CITY OF ALBUQUERQUE

May 23, 2016

**Re: Independence Square
Erosion and Sediment Control Plan
Engineer's Stamp Date 5-23-16 (E17E076)**

Erosion Sediment Control Plan

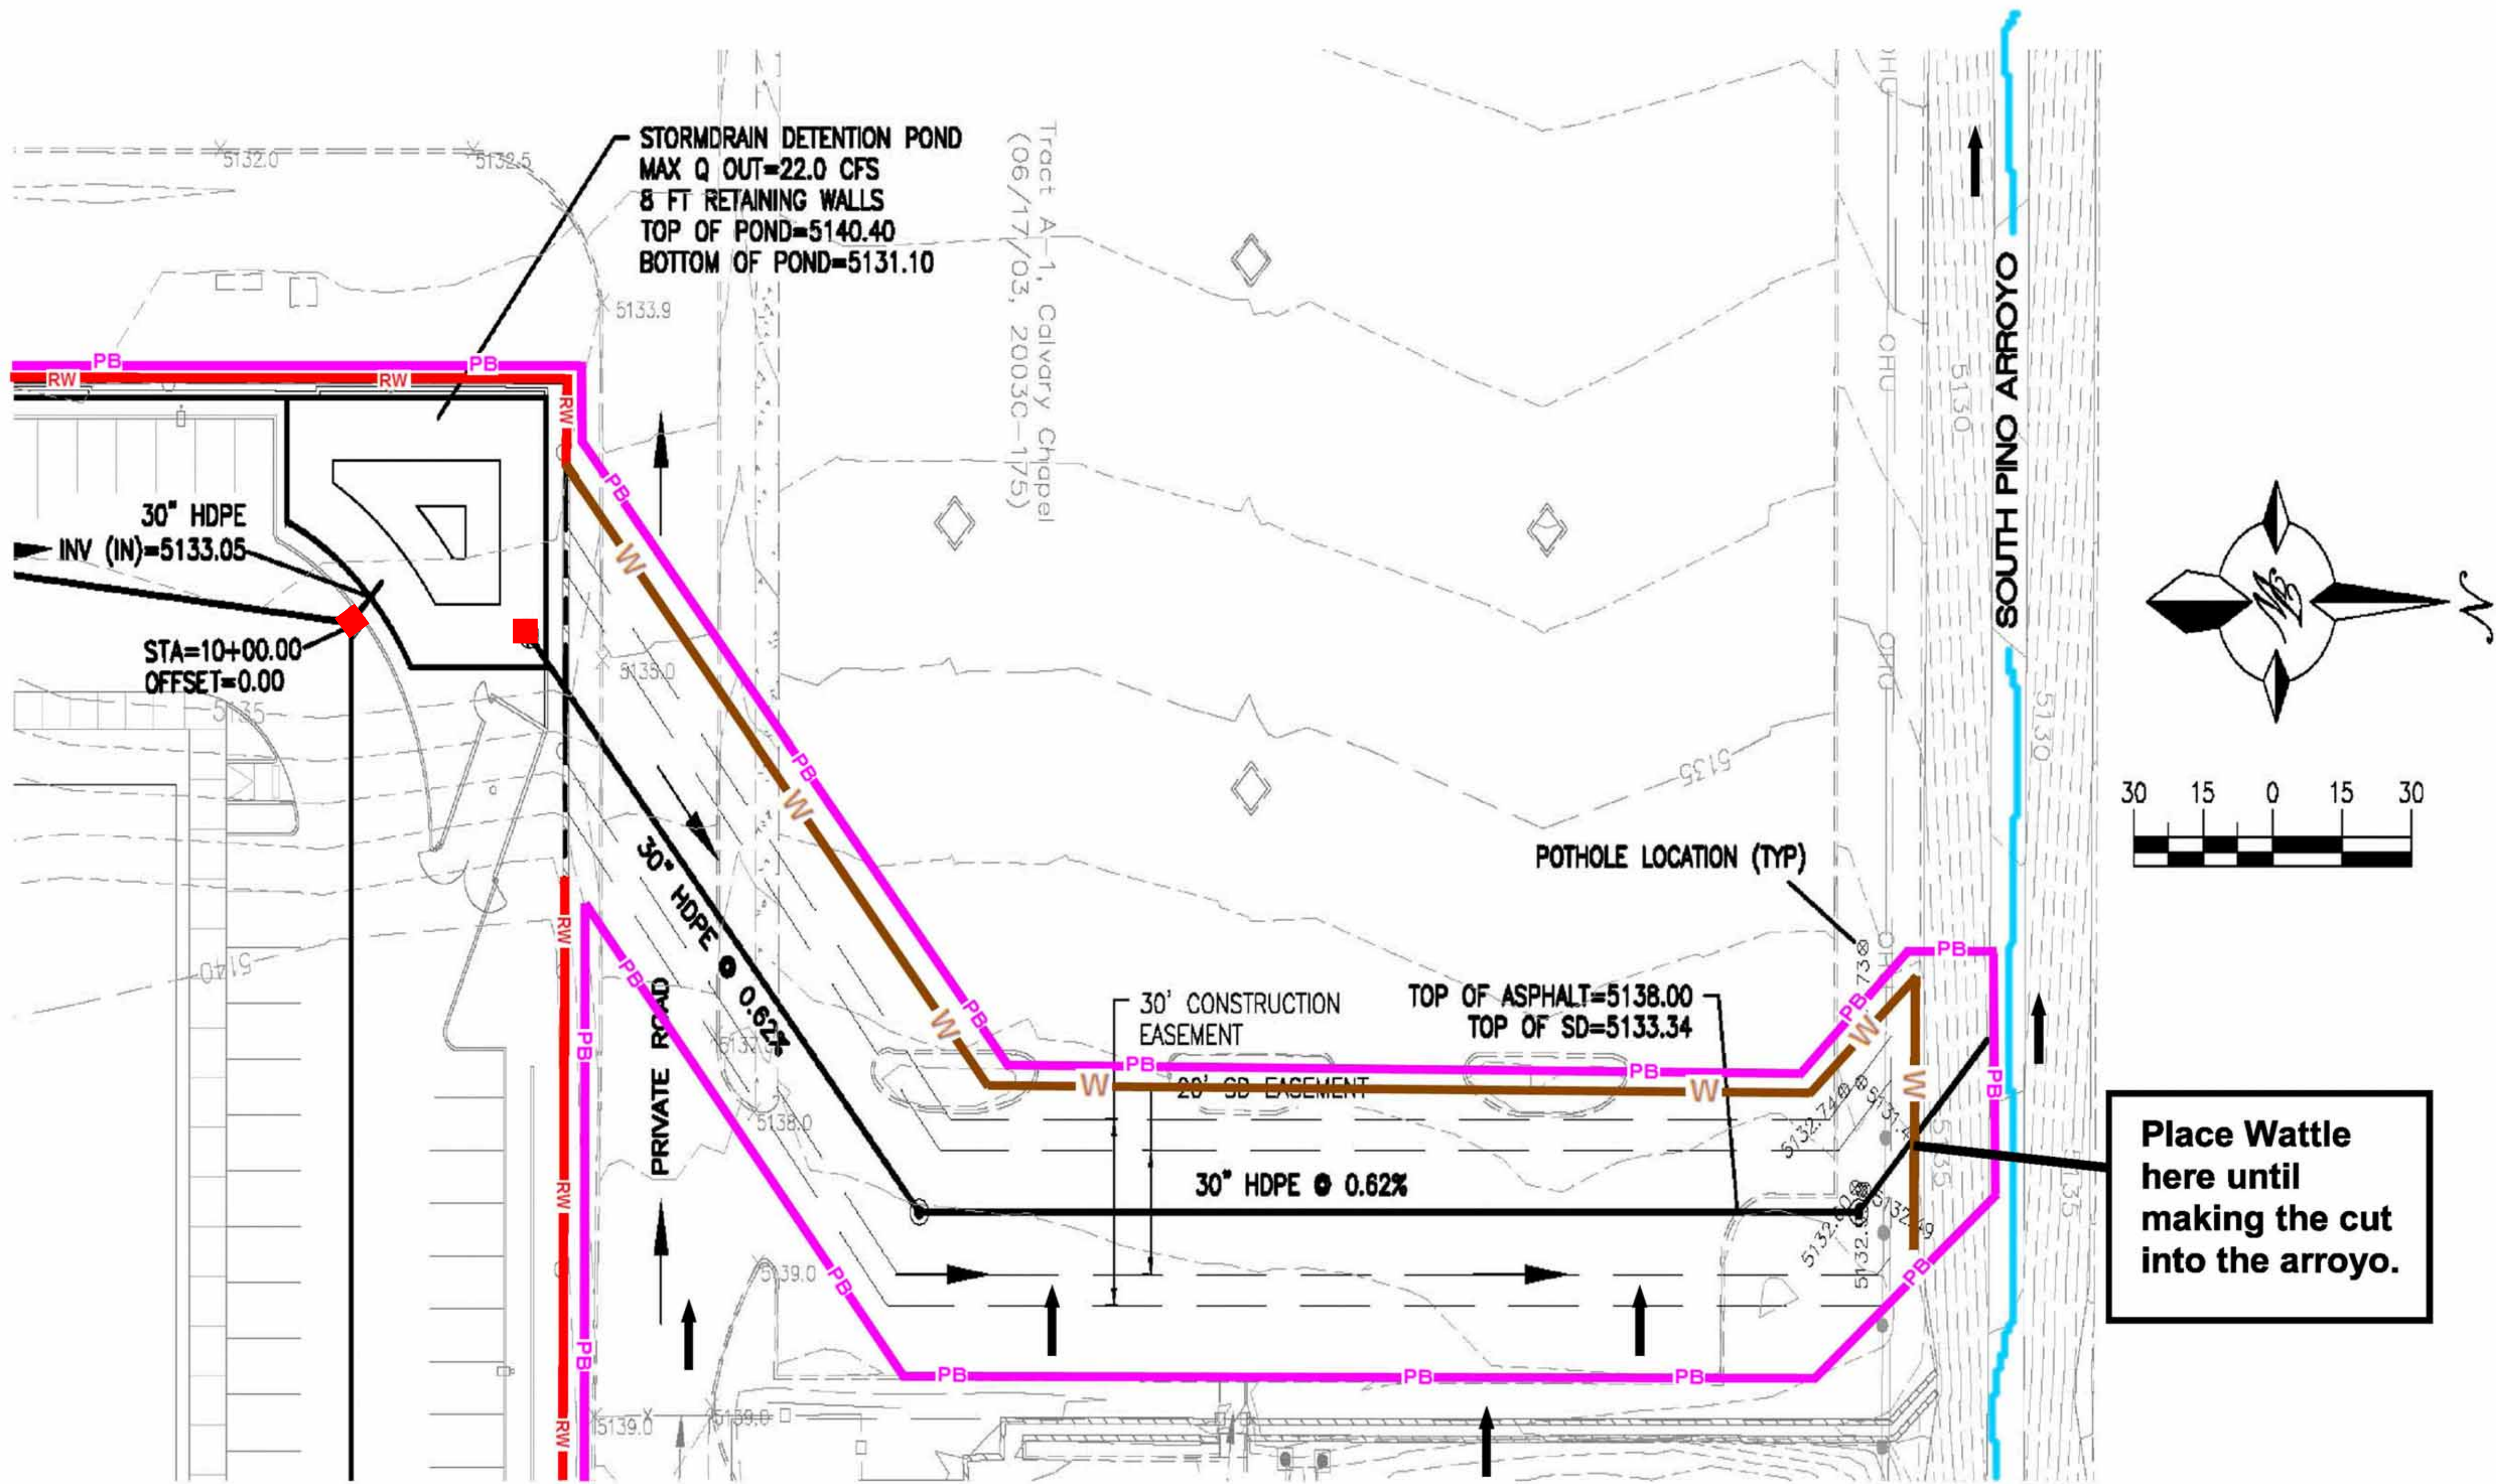
1. The plan submitted only shows the connection to the Pino Arroyo and did not address comment #2 from the last letter "Storm inlets are shown, but inlet protection is not specified and comment #3 "A Curb Storm Drain Inlet Filter" is shown, but the inlets appear to be "at grade" not in a curb."
2. The entire plan (site and connection to the Pino arroyo) should be resubmitted.
3. The information sheet requested Construction Plan Work Order approval; however, the scope of the Construction Plan Work Order is not included and is not clear.
